Application no: H02/0812/01

Description: Refurbishment of 7-11 and new  
house and bungalow with  
garages at rear

Location: 7-11 East Street  
Crowland

Amendment: Changes to bungalow roof  
dwg no. CRO 002 rev 21 Aug 01

SCALES 1 / 100
 DRG. NO. CRO 002 DATE JUNE 01

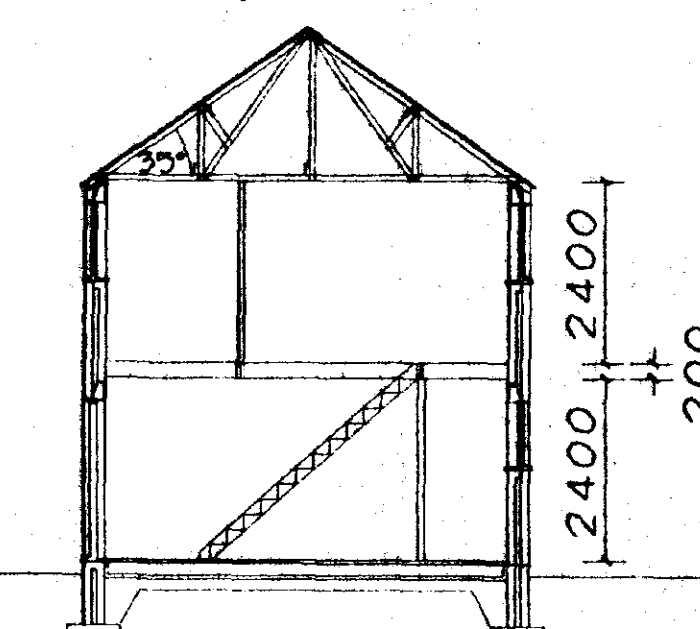
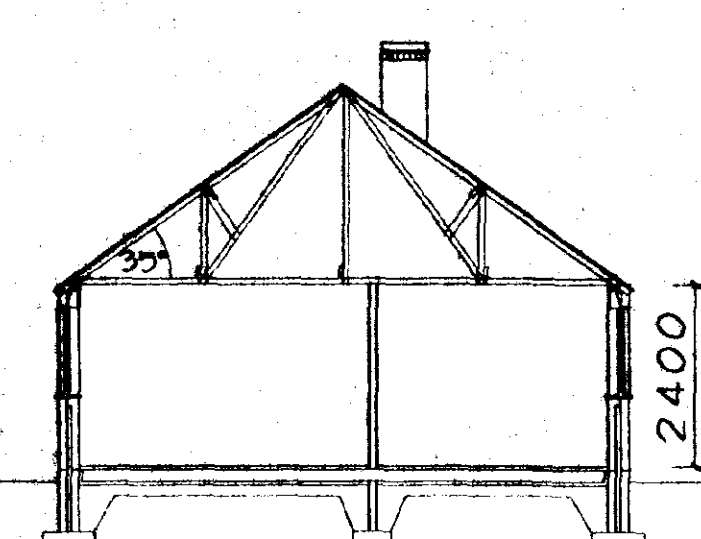
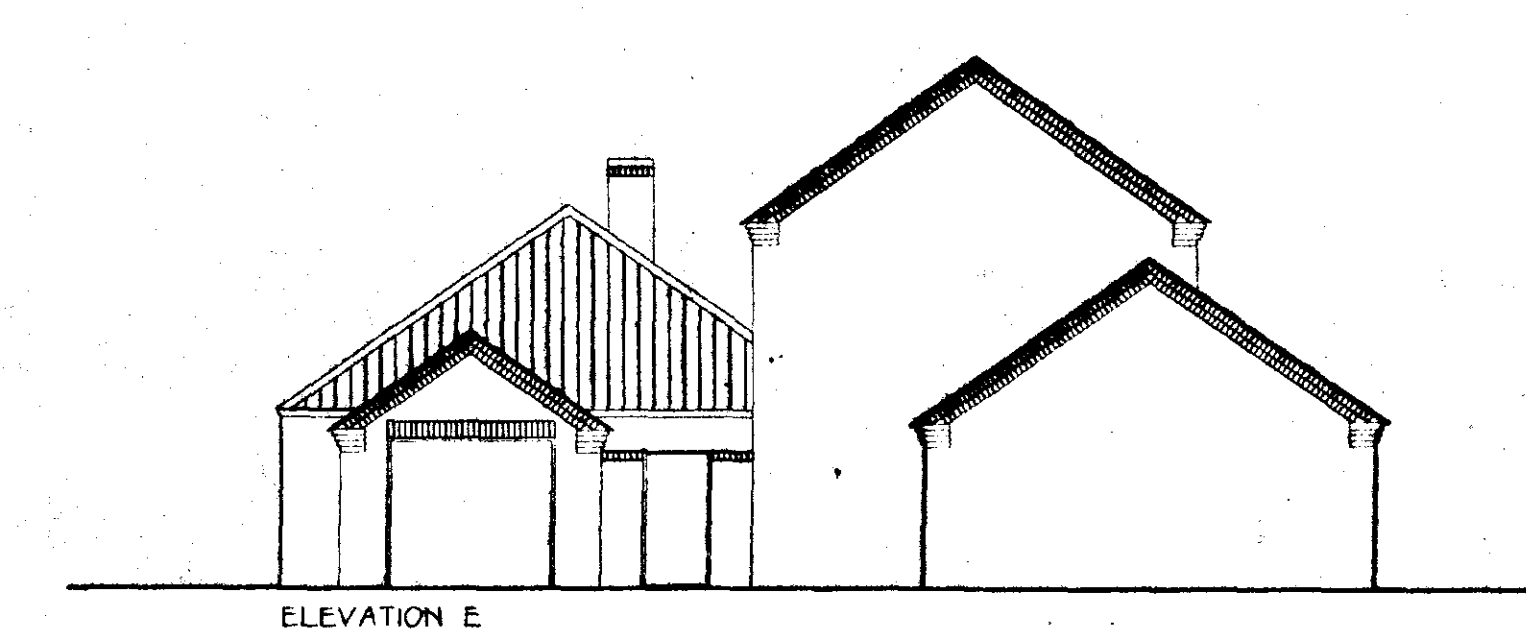
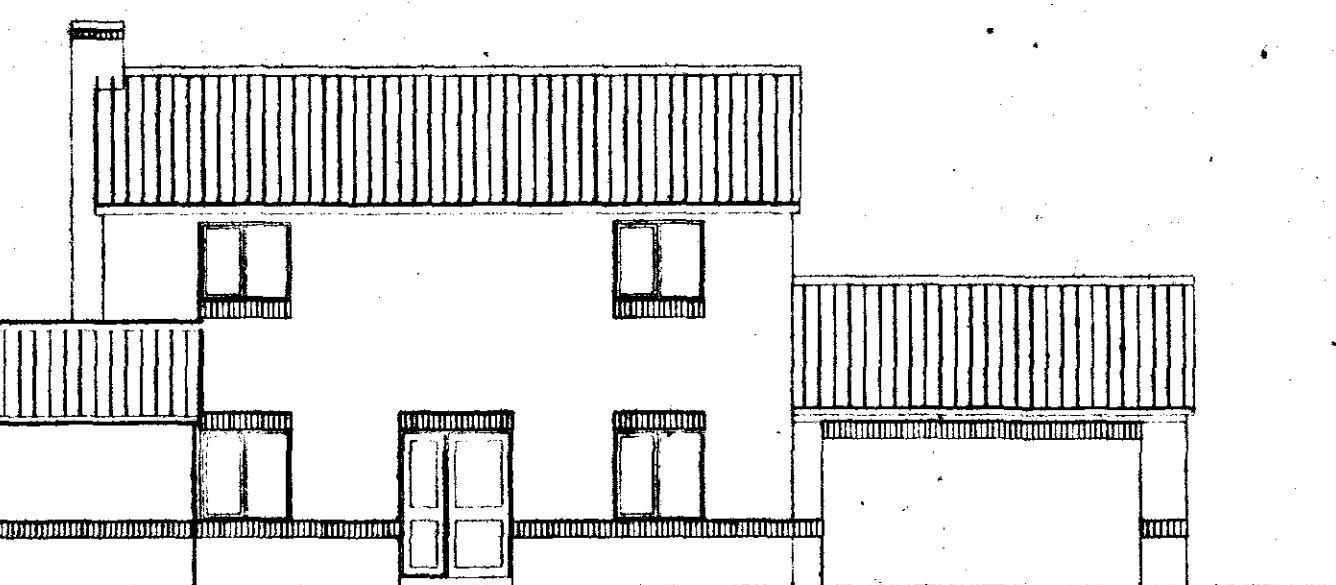
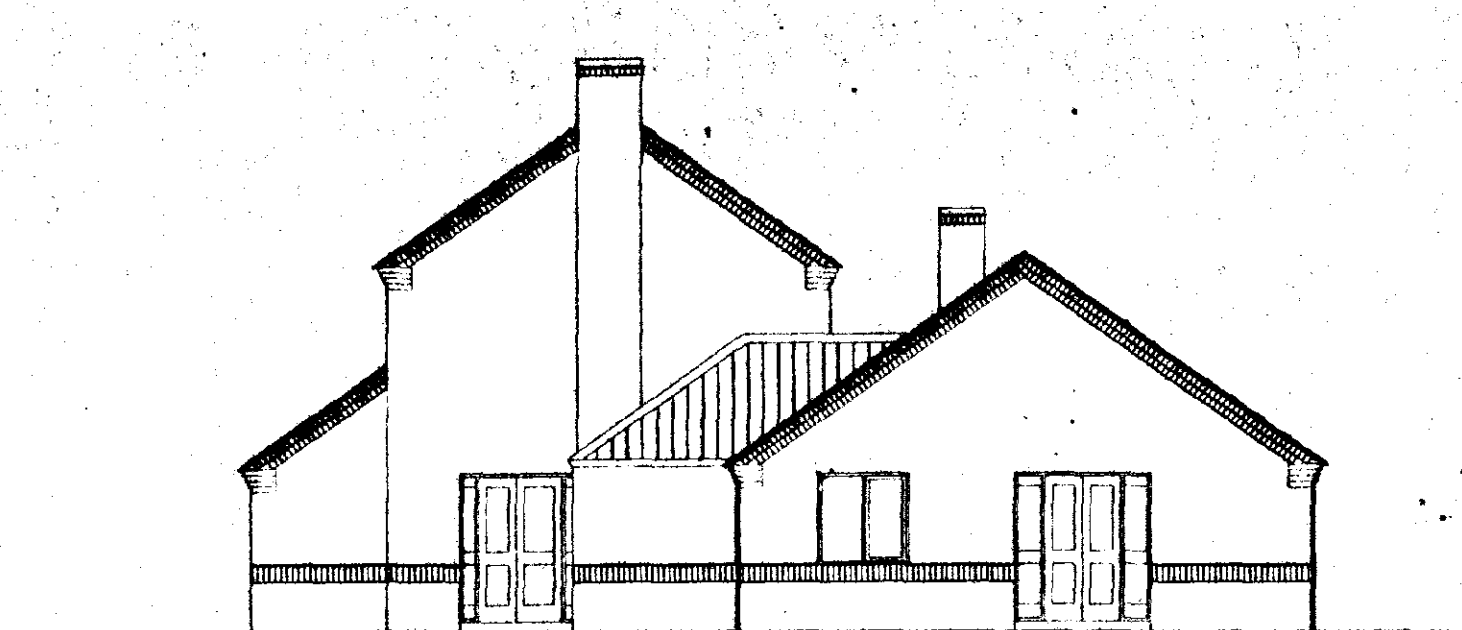
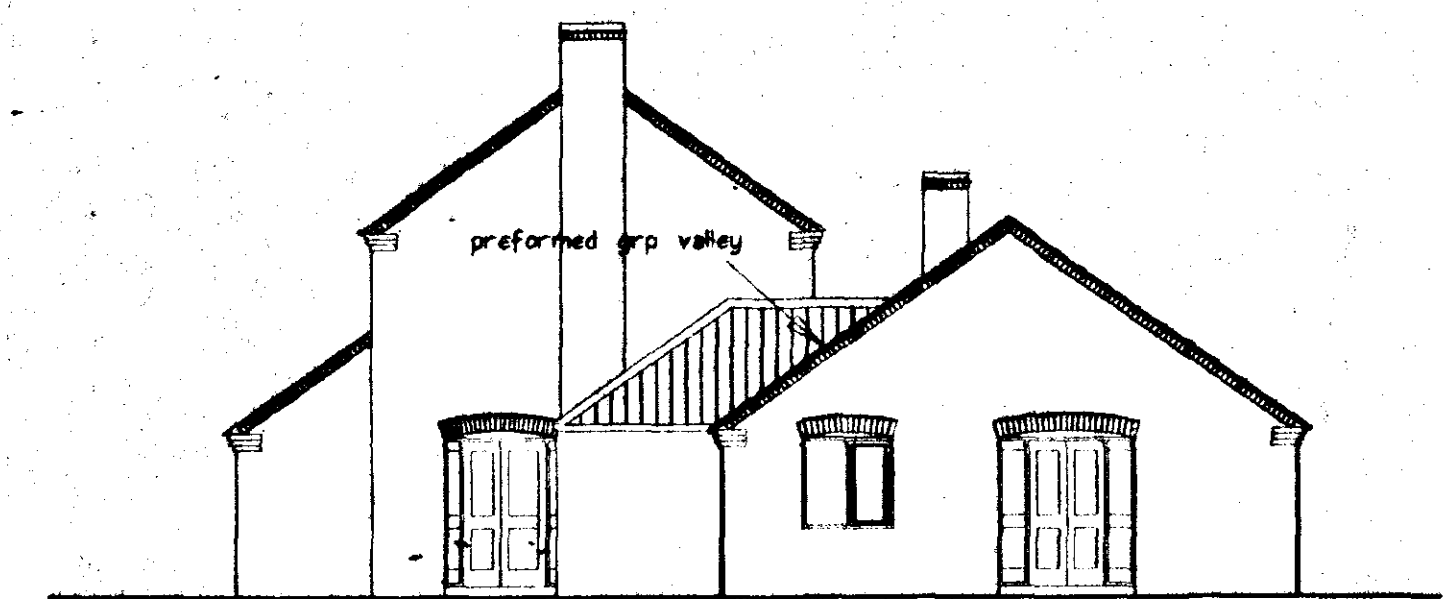
We recently met Mr Scriven the conservation officer to discuss possible changes to the bungalow roof and an alternative design was agreed upon. Two copies of the revised plan are enclosed and we hope that the scheme will meet with your approval.
